**Colorado's Power Pathway – Xcel Energy Responses to El Paso County Referral Comments**

COLORADO'S POWER PATHWAY

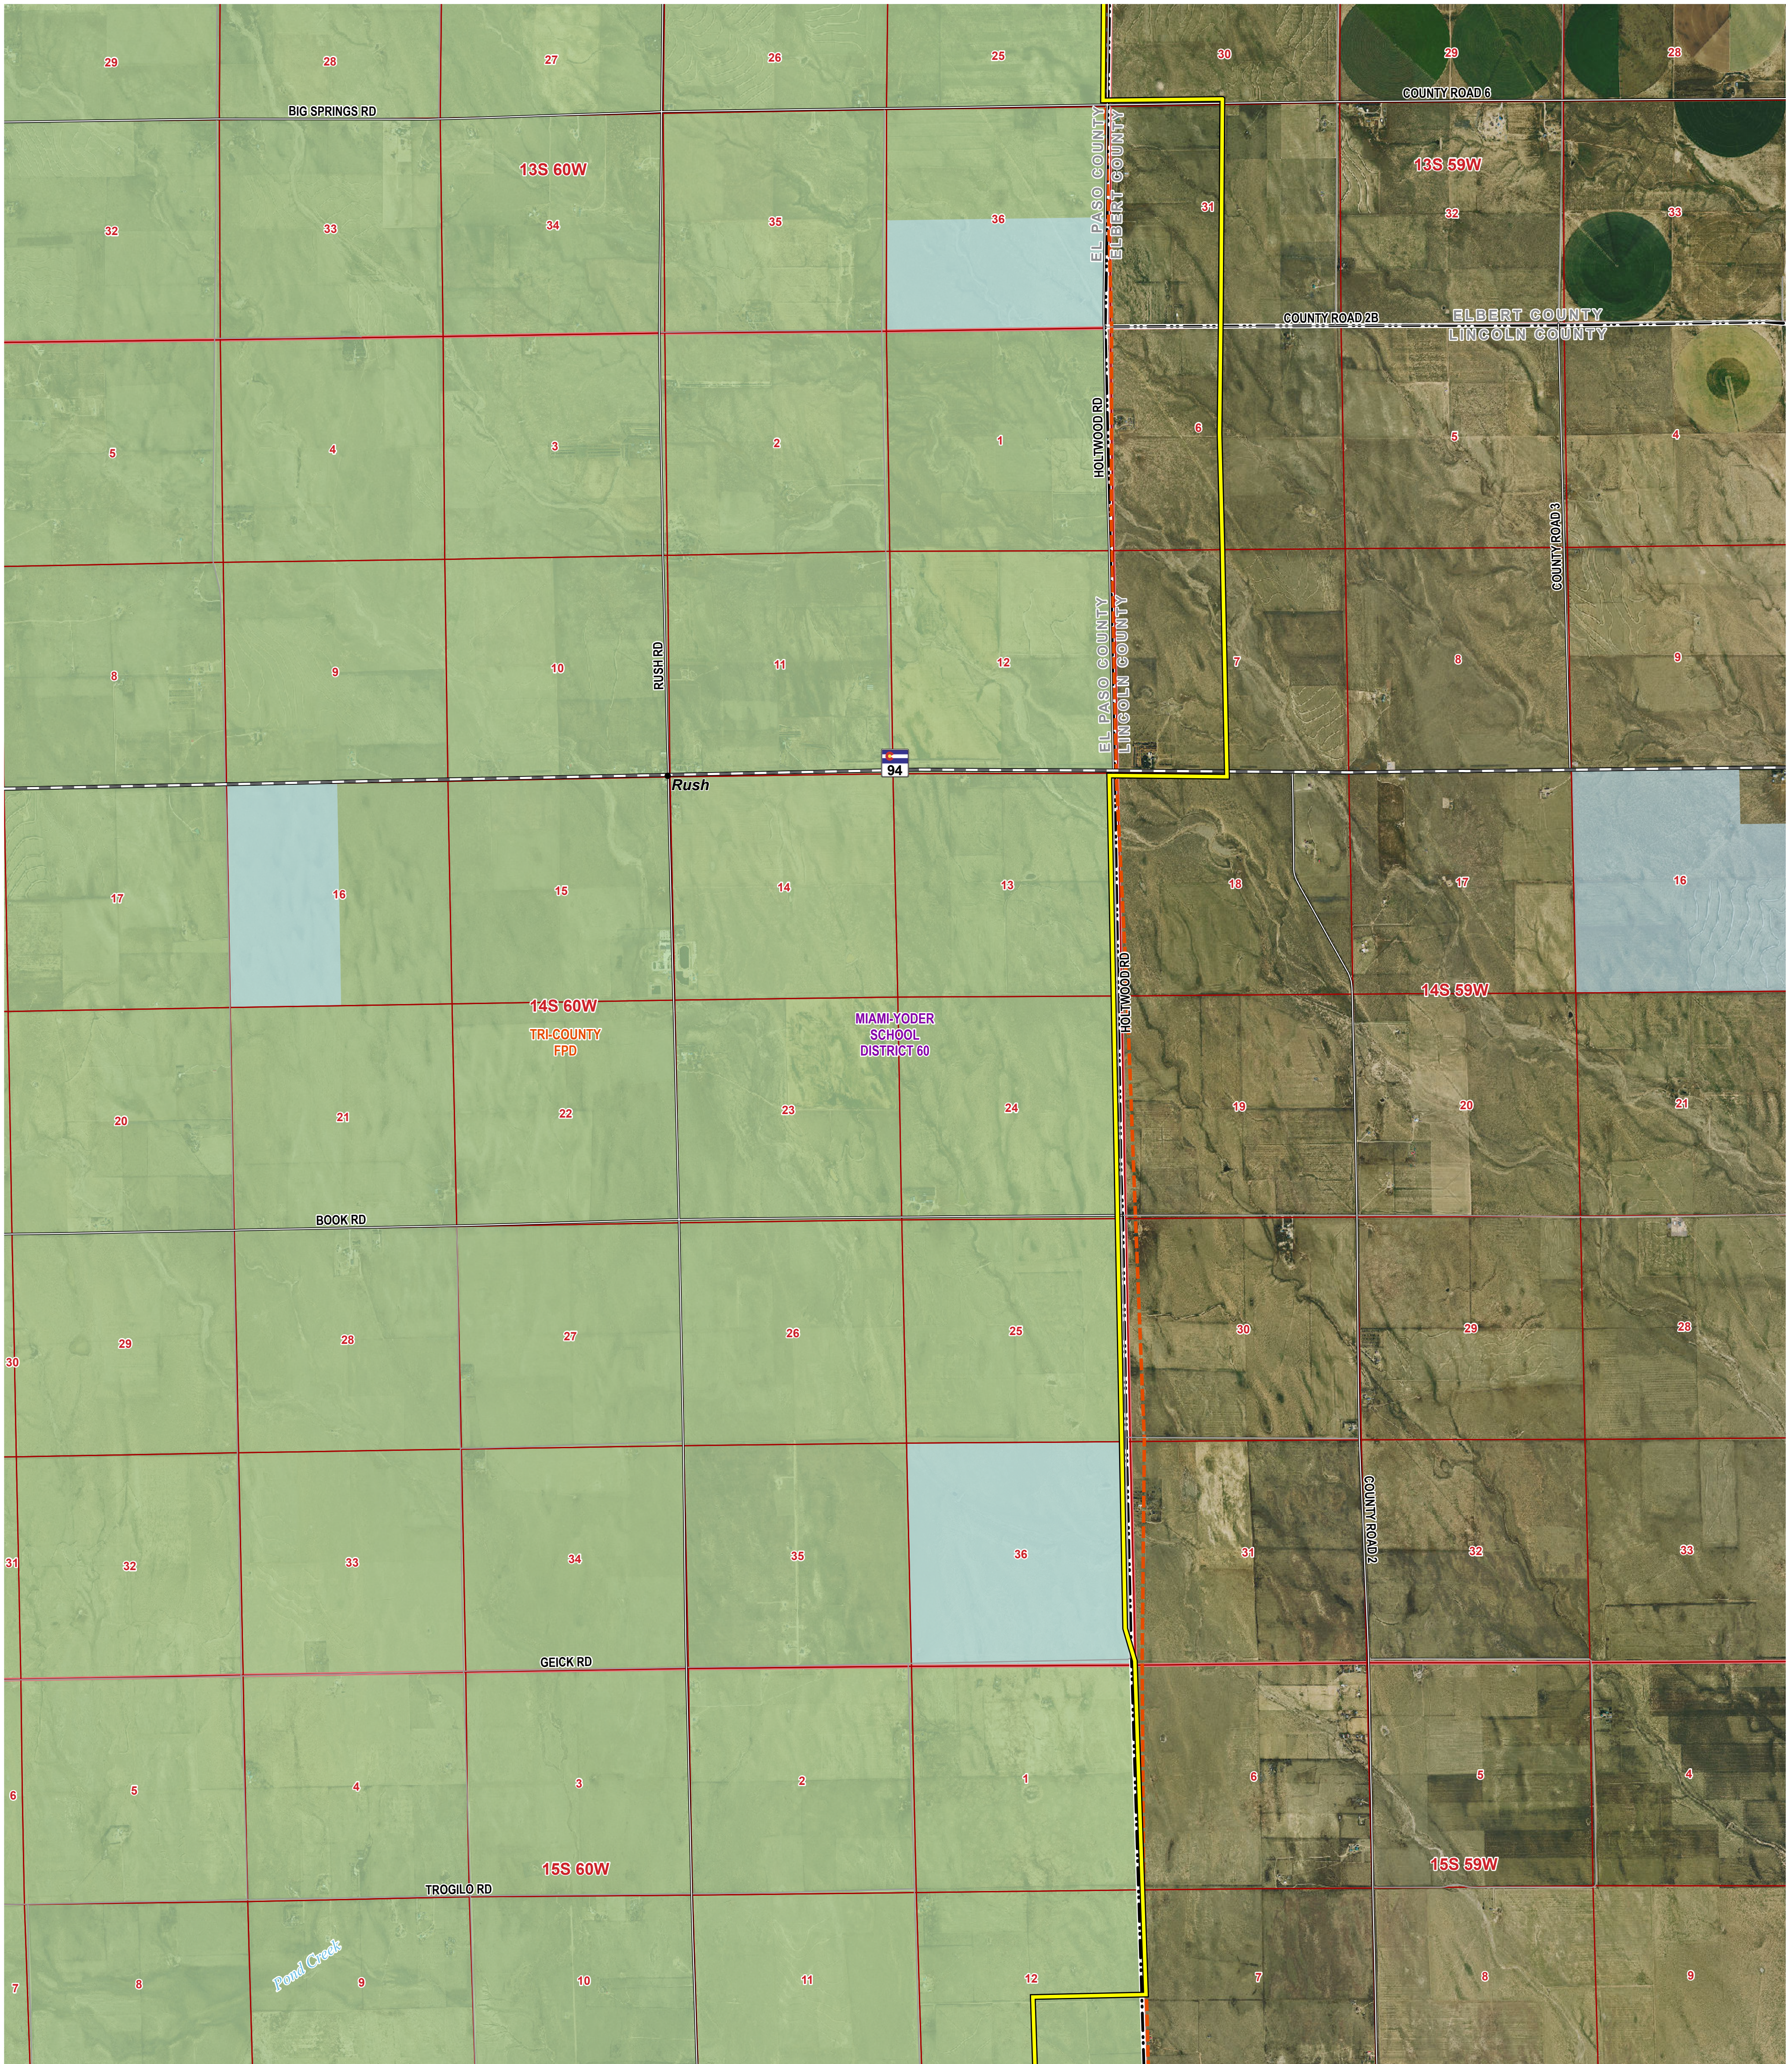
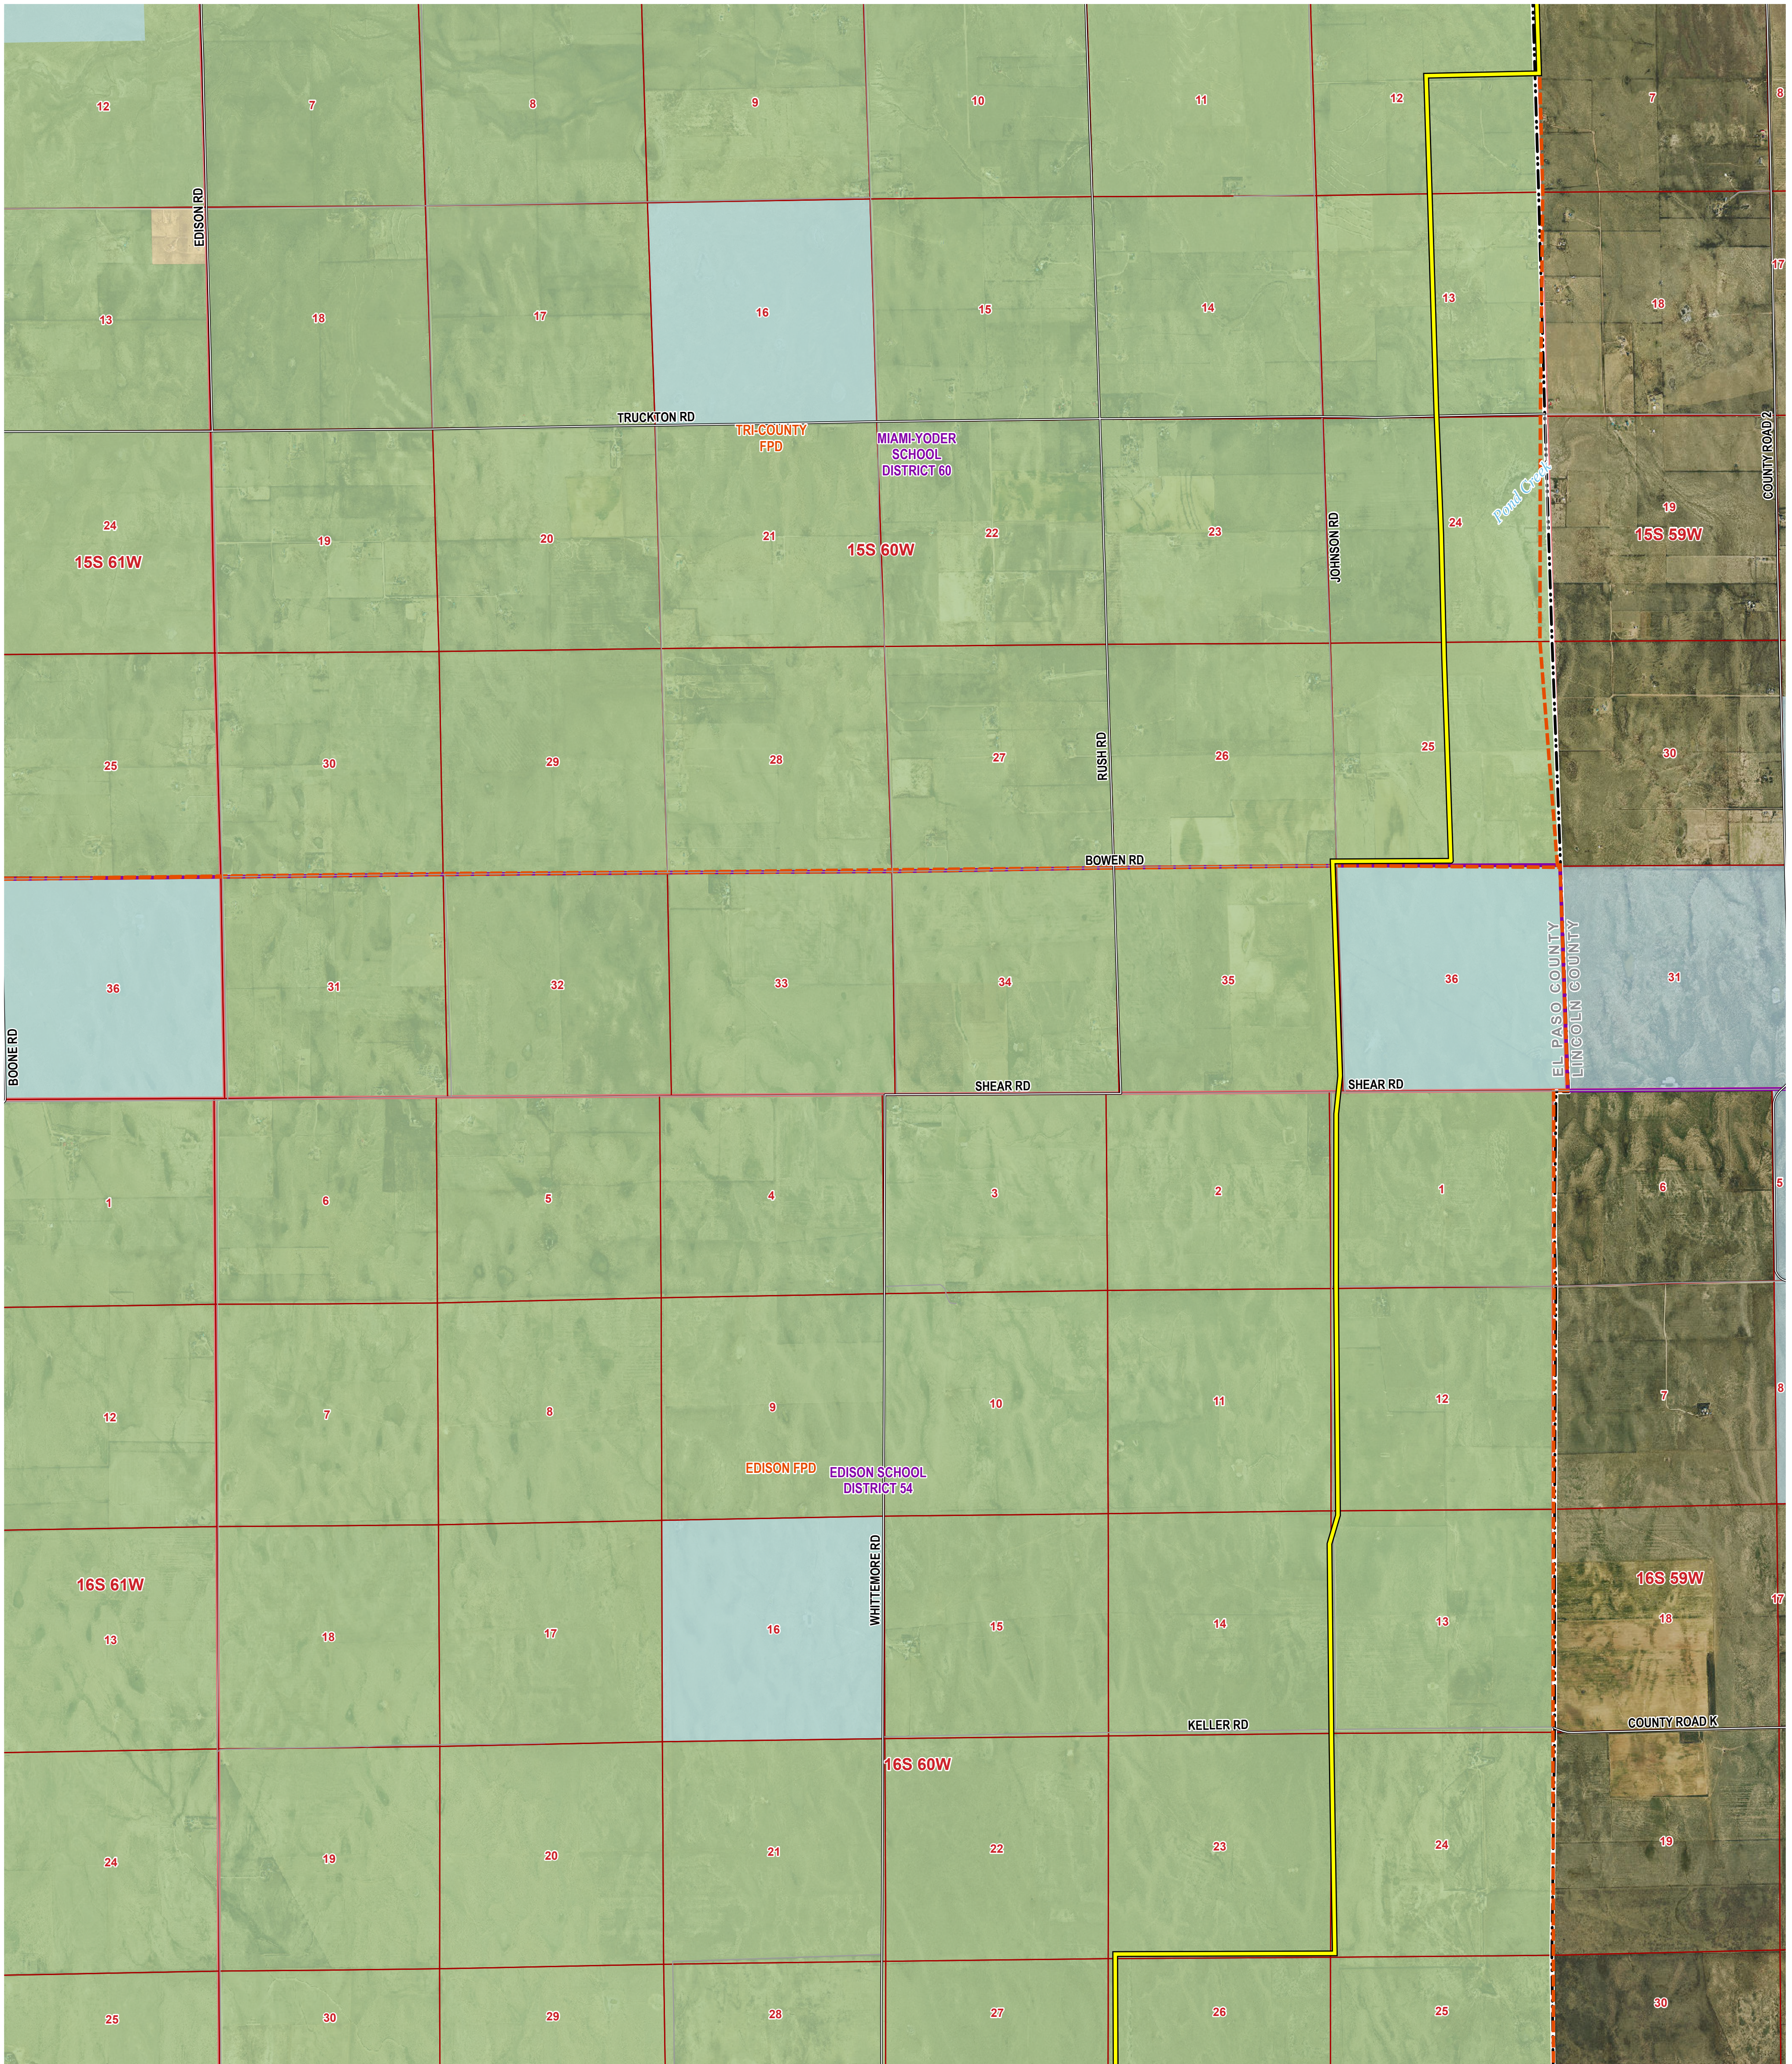
1. You have provided a zonemap- Please add a symbol or label of land use- is land adj to line vacant; has residence; commercial business- the land use is not identified in the exhibit.	The Land Use and Zoning Map has been revised to indicate adjacent land uses. The revised Land Use and Zoning Map is provided as Resubmitted Attachment F.
<b>PCD Project Manager_2024-08-19_Comment.txt</b>

1. Zoning and Land Use Map- No land-uses were shown.	The Land Use and Zoning Map has been revised to indicate land uses. The revised Land Use and Zoning Map is provided as Resubmitted Attachment F.
<b>PCD Project Manager_2024-08-19_003.pdf</b>	
Attachment I: Transportation Memorandum 1. See comments on Haul Route Plan and update accordingly	The Revised Transportation Memorandum has been updated to address comments received in the following documents: <ul style="list-style-type: none"> <li>• El Paso County PCD – Project Manager_2024-08-19_004</li> <li>• Colorado Department of Transportation - Pueblo Office_2024-07-18_Comment</li> </ul> The Revised Transportation Memorandum is provided as Resubmitted Attachment I.
<b>PCD Project Manager_2024-08-19_003_Comment.txt</b>	
Traffic impact Study Comments	The Revised Transportation Memorandum has been updated to address comments received in the following documents: <ul style="list-style-type: none"> <li>• El Paso County PCD – Project Manager_2024-08-19_004</li> <li>• Colorado Department of Transportation - Pueblo Office_2024-07-18_Comment</li> </ul>
